KITITAS COUNTY

MEMORANDUM

TO: Community Development Services
FROM: Taylor Gustafson, Environmental/Transportation Planner
DATE: March 15, 2019
SUBJECT: Kuenzli BL-19-00001

In review of the preliminary survey, Public Works has the following comments:

SHEET 1 OF 2

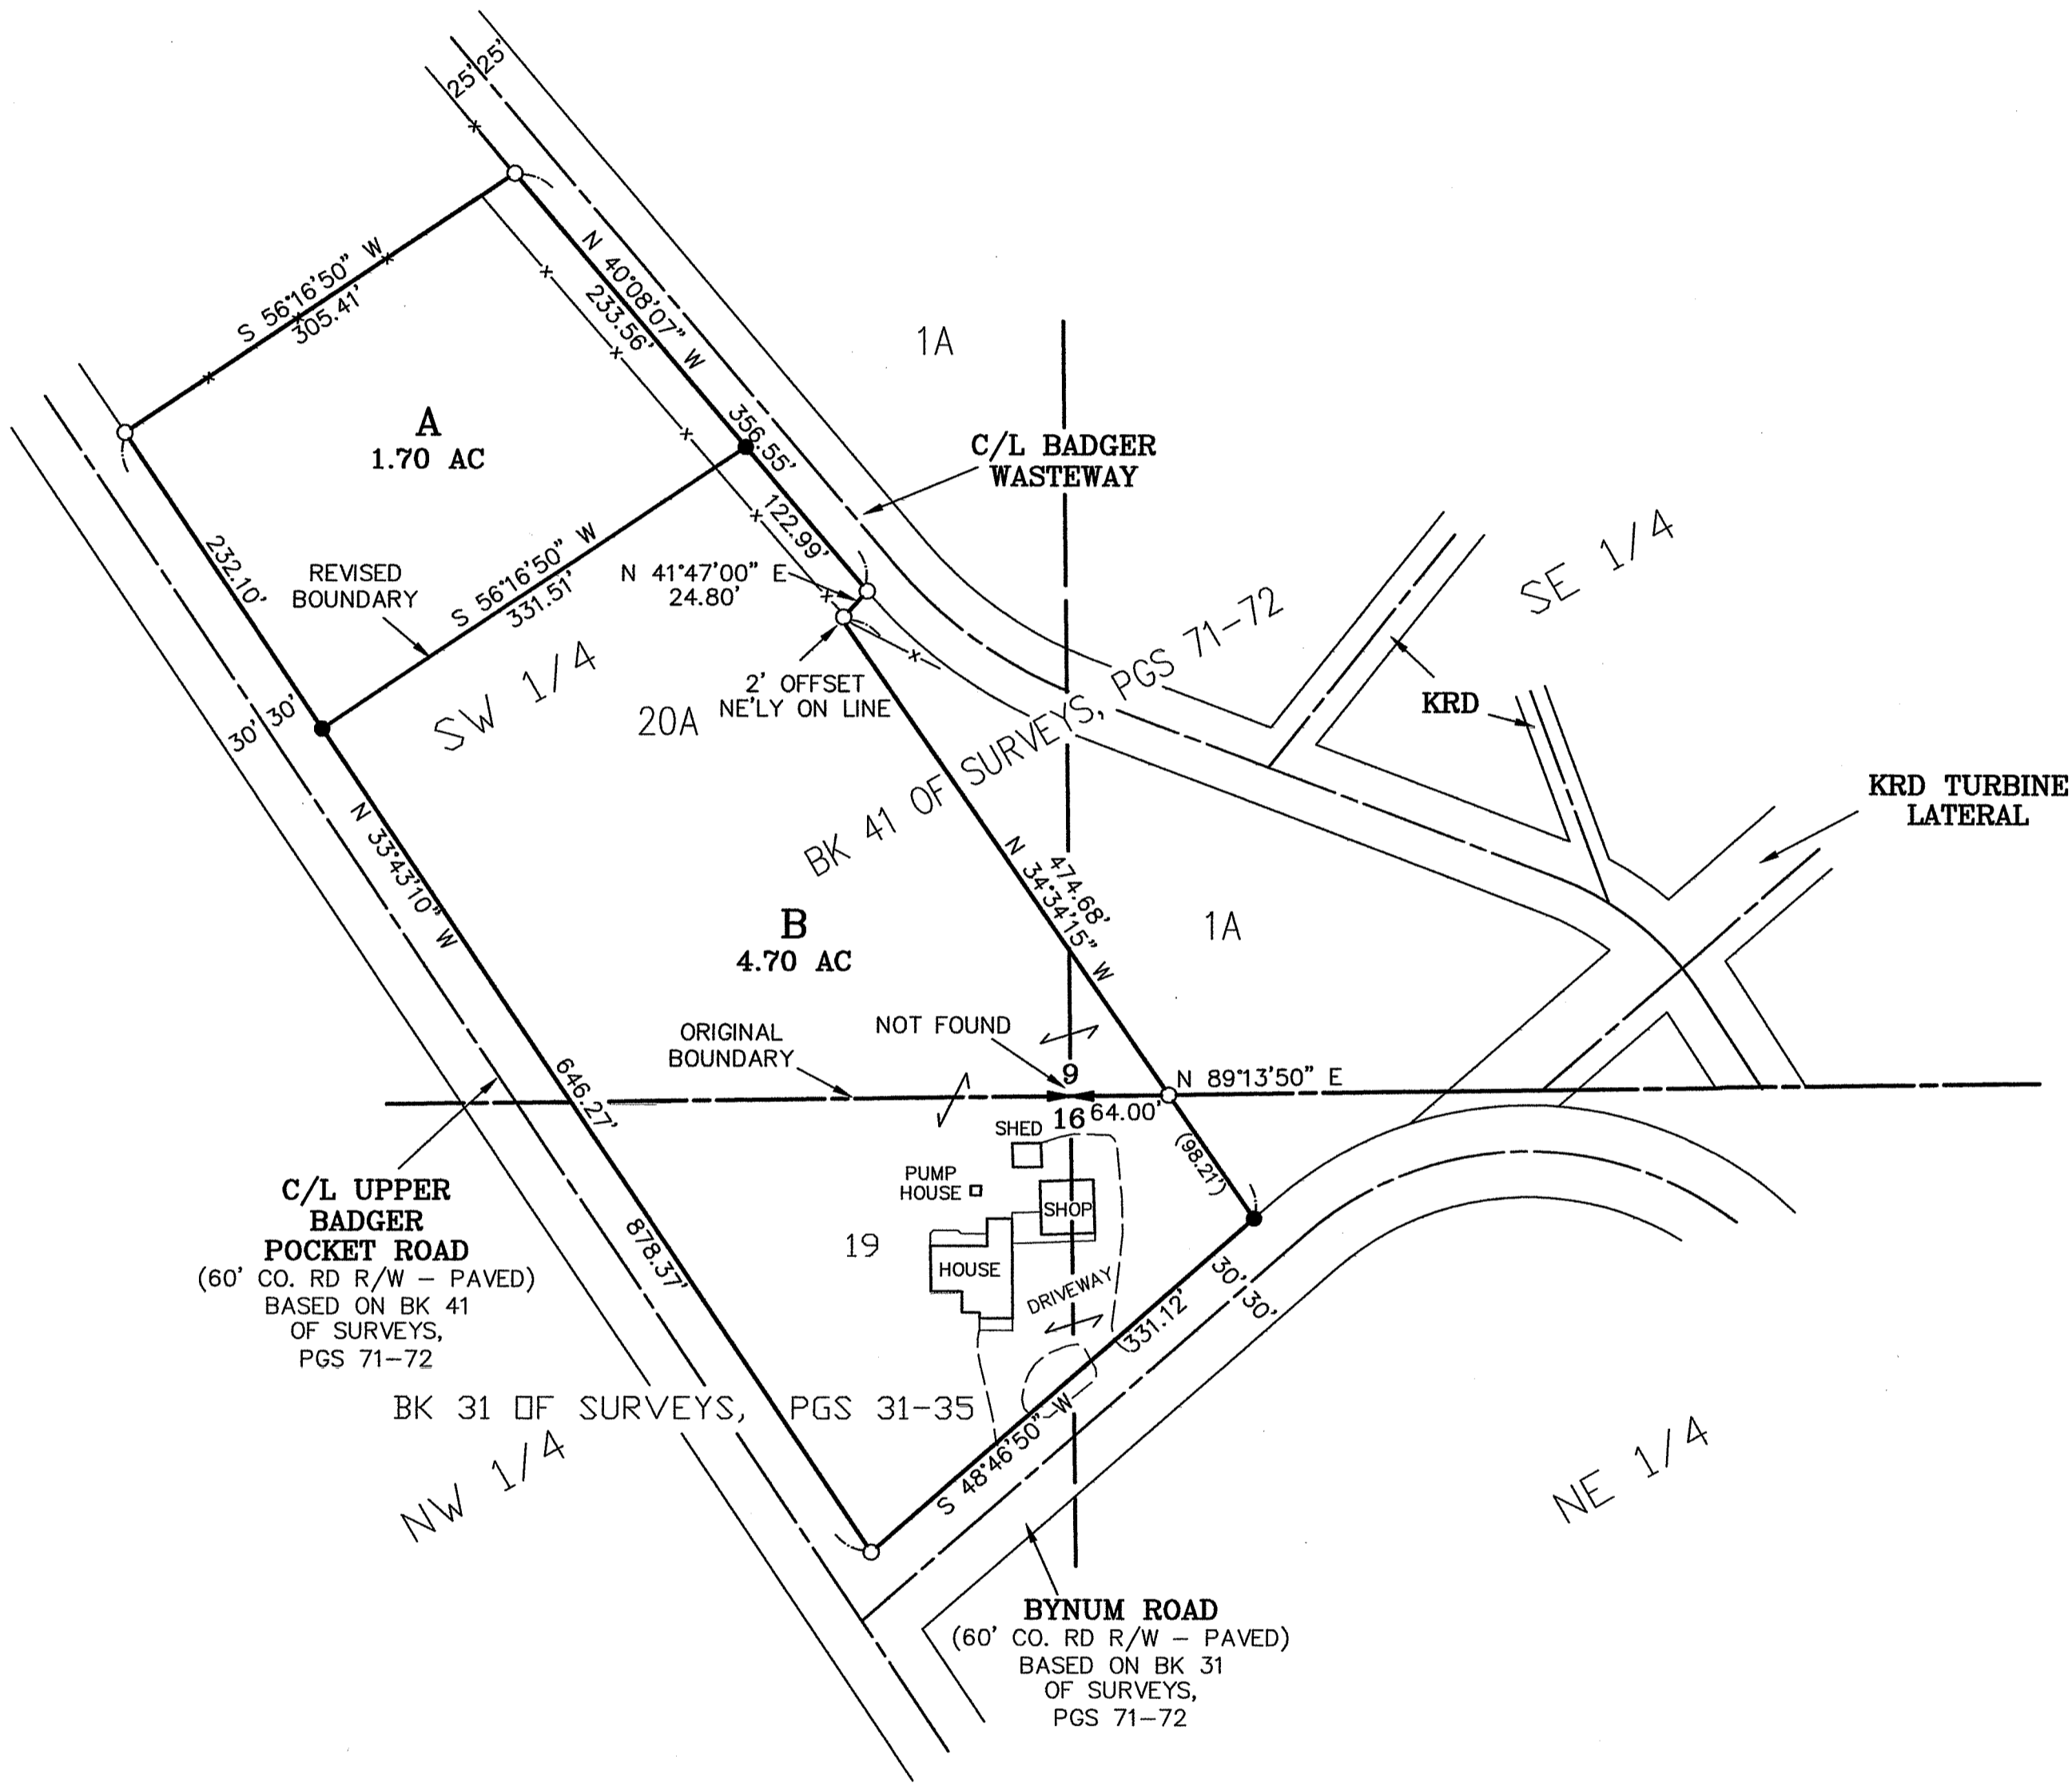
1. The distance shown along Badger Wasteway of 356.55 is partially obscured and may become illegible after scanning by the DNR.
2. Minor typo within Note 9.
3. The legal description of the adjusted parcels includes a recording Date of February 2019.
